Recommendation Report for Planning Permission for Works or Extension to a Dwelling

REF NO: FG/135/18/HH

LOCATION: 14 Sark Gardens
Ferring
BN12 5QB

PROPOSAL: Single storey side & rear extensions, conversion of garage to habitable accommodation with new roof over & insertion of roof window & sun pipes.

**Proposed Elevations and Section
Scheme 3**

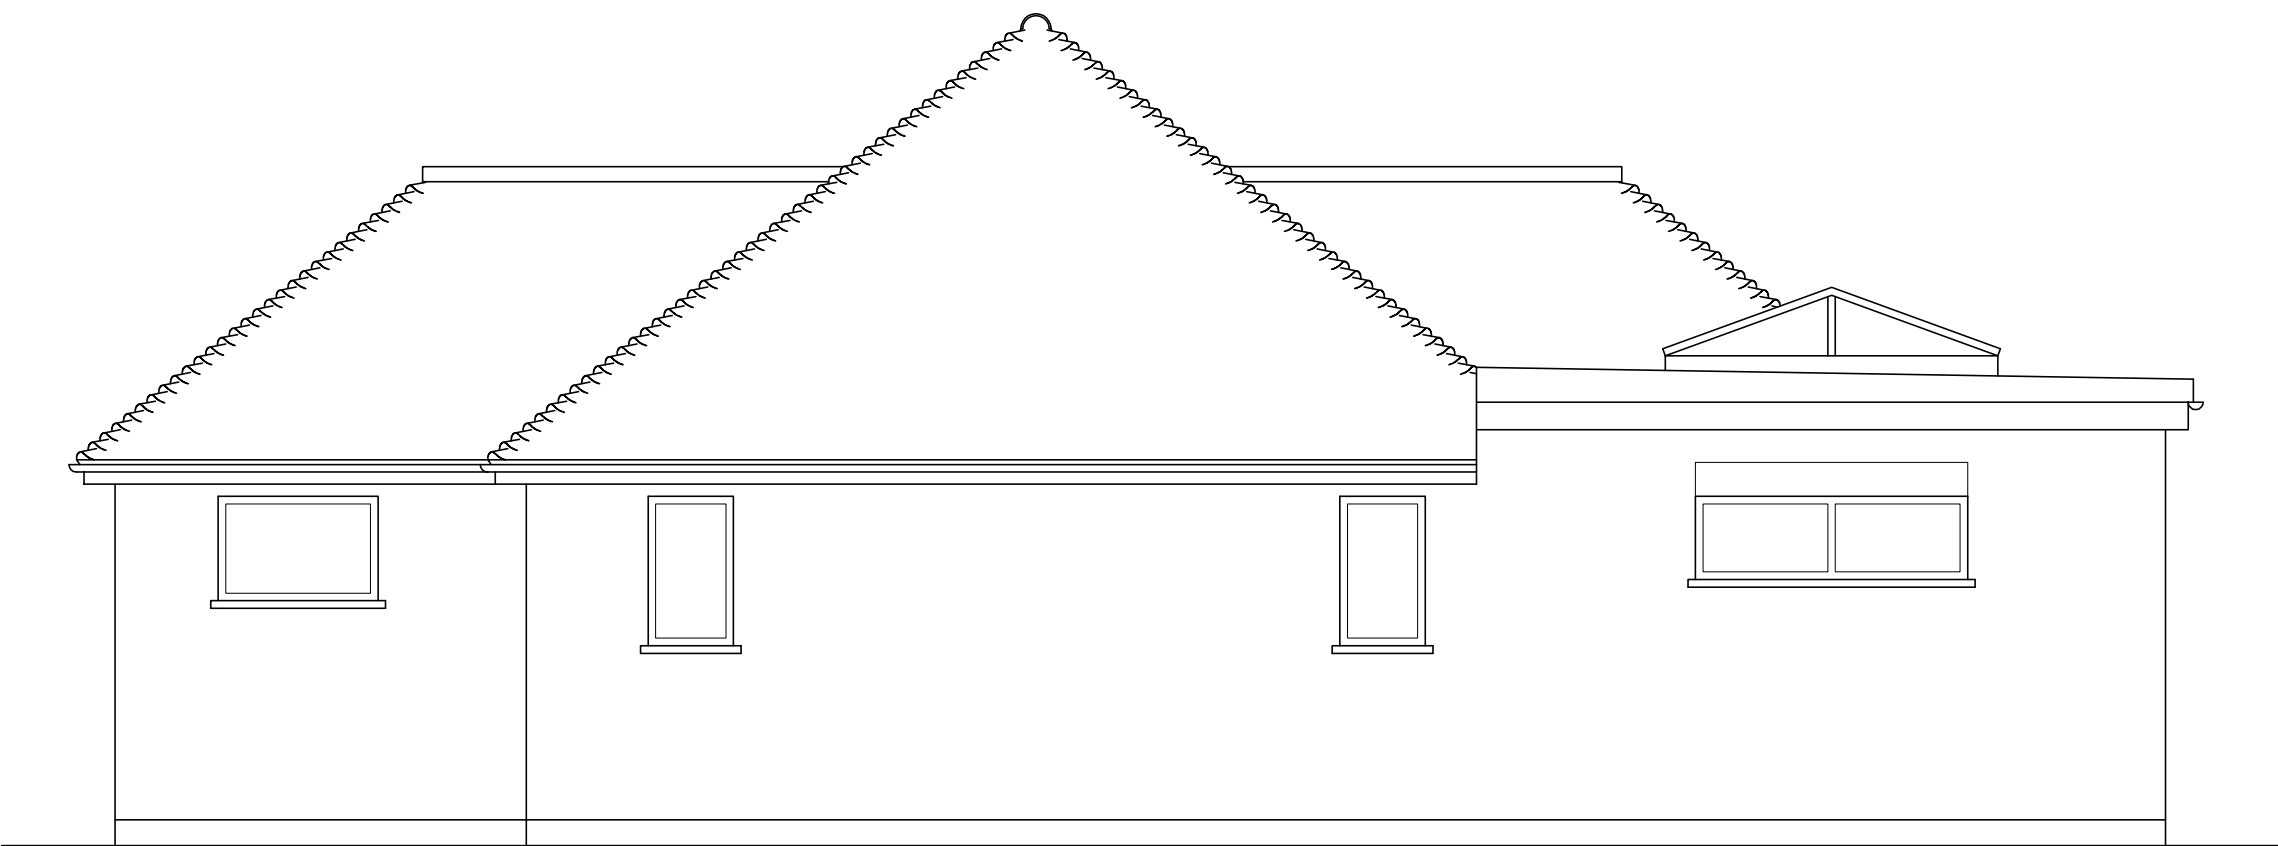
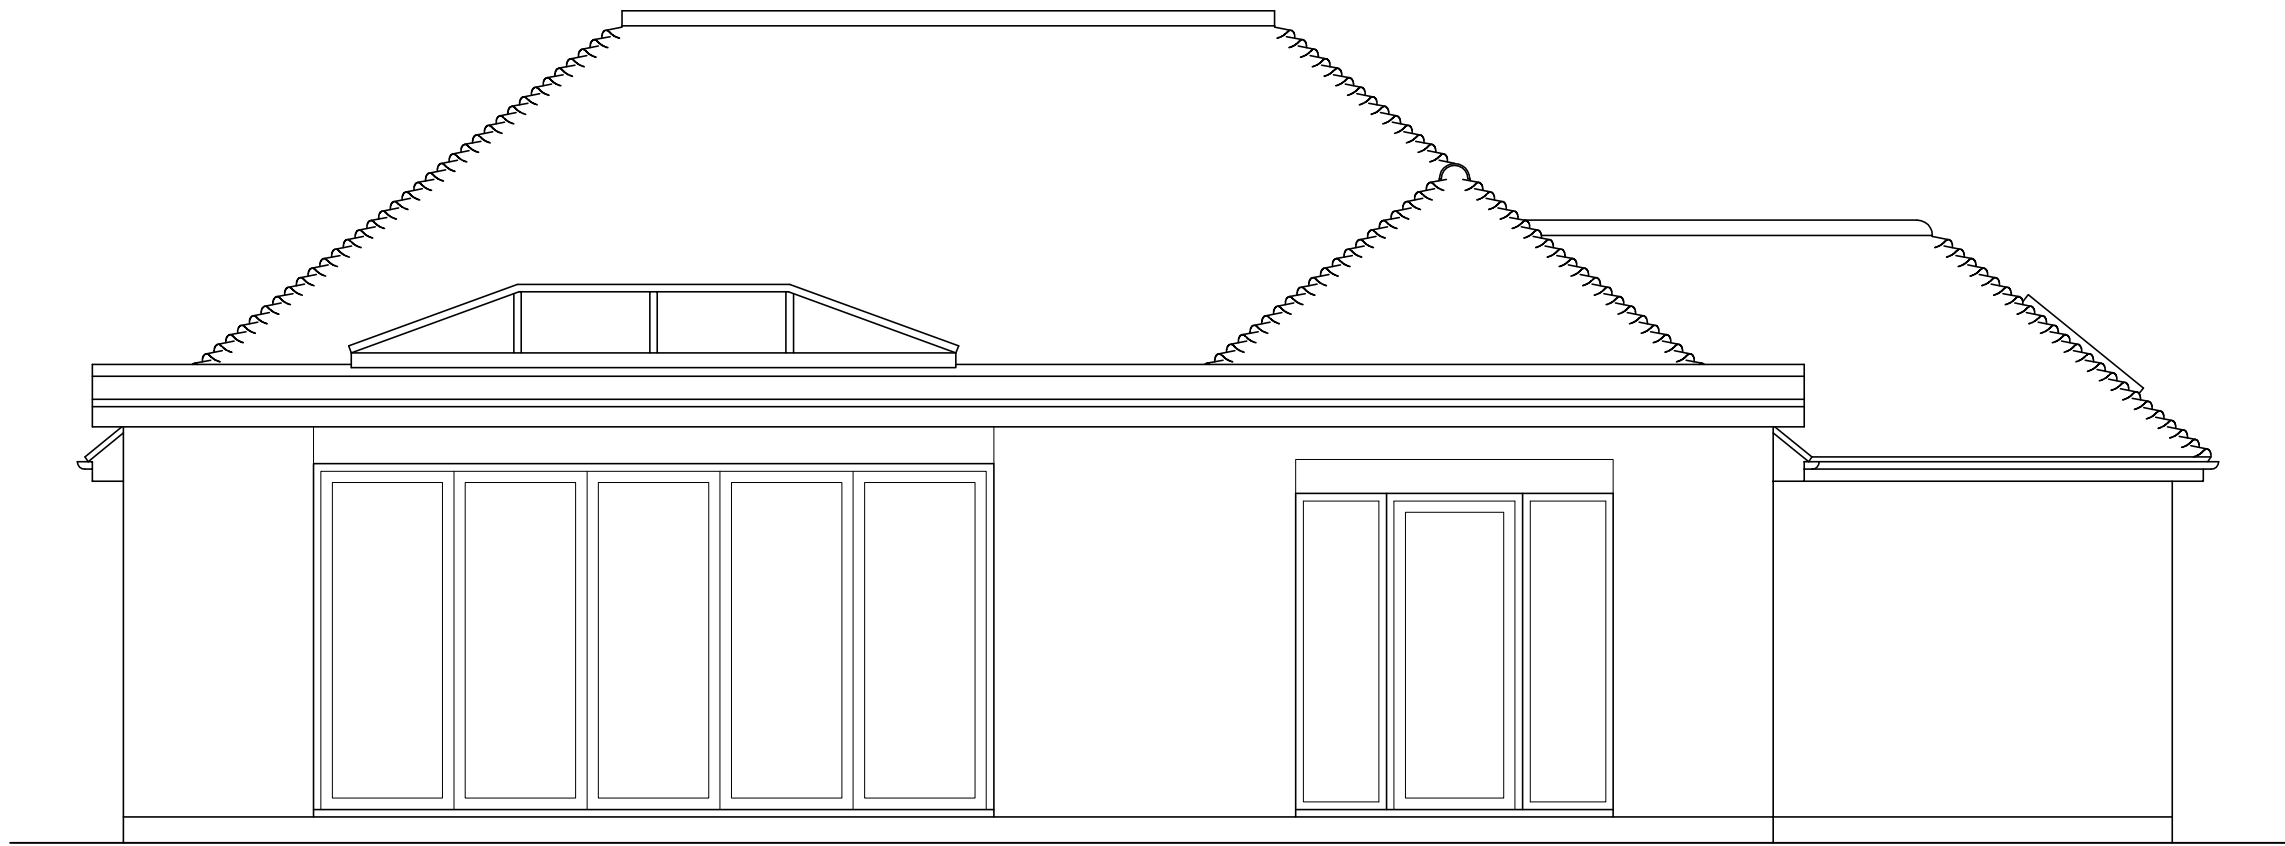
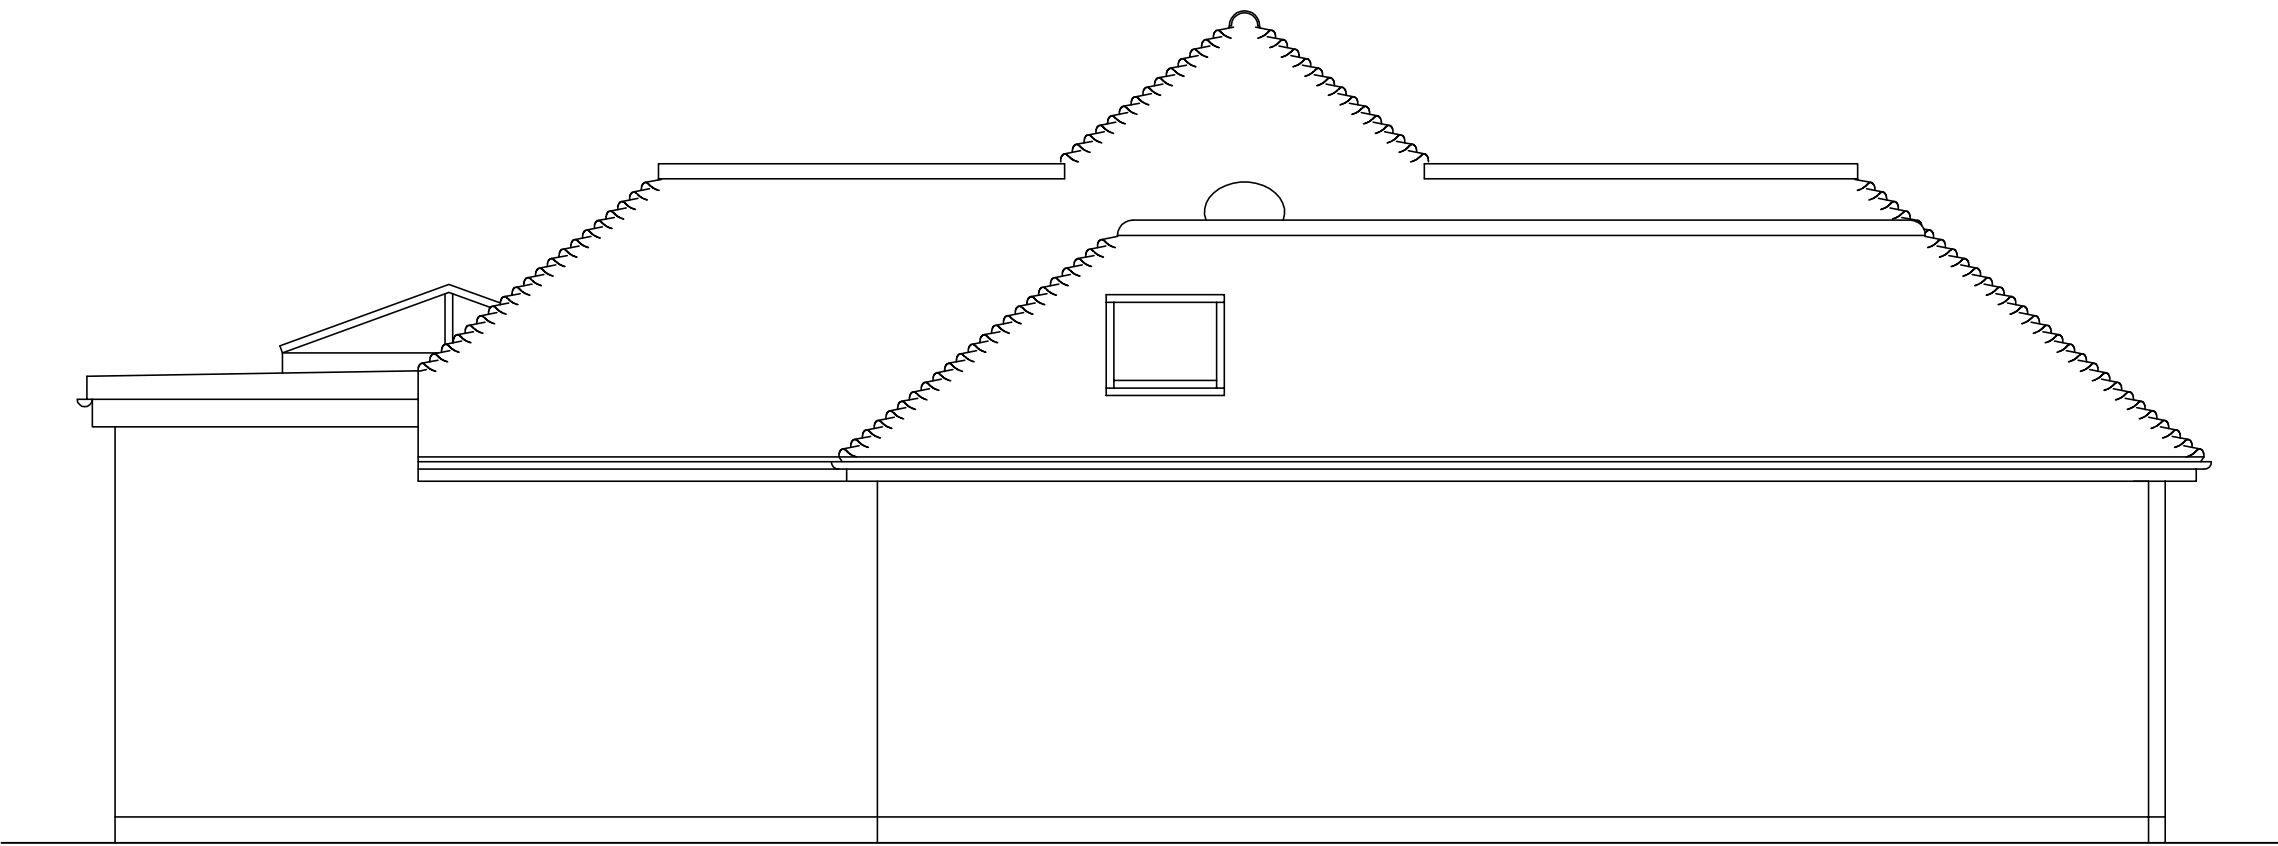
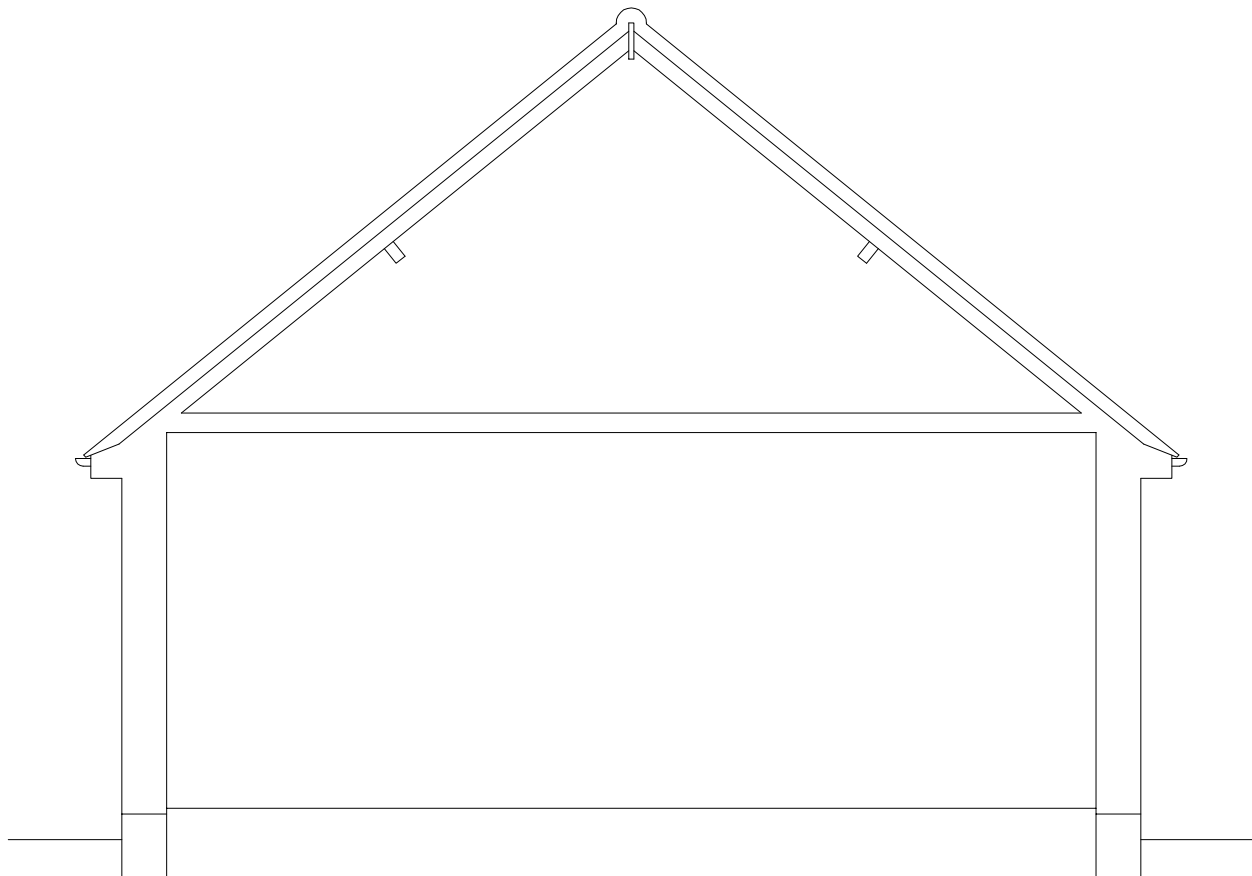
The existing garage flat roof would be replaced with a pitched roof and would join with the existing front projection to the host dwelling. Due to the modest scale and matching materials, the proposed development it is considered to appear subservient and sympathetic in appearance to the host dwelling. The proposed development is not considered to be visually obtrusive or prominent and is not deemed to have an adverse impact on the character or appearance of the host property or wider area and accord with DDM1 and DDM4 of the Arun Local Plan.

At the rear of the property an existing conservatory will be replaced with a rear extension which will run the width of the dwelling. The rear extension will increase in depth by 1.5m to 4.5m and the height will also increase to eaves of 3.2m and a maximum height of 3.65 with roof light.
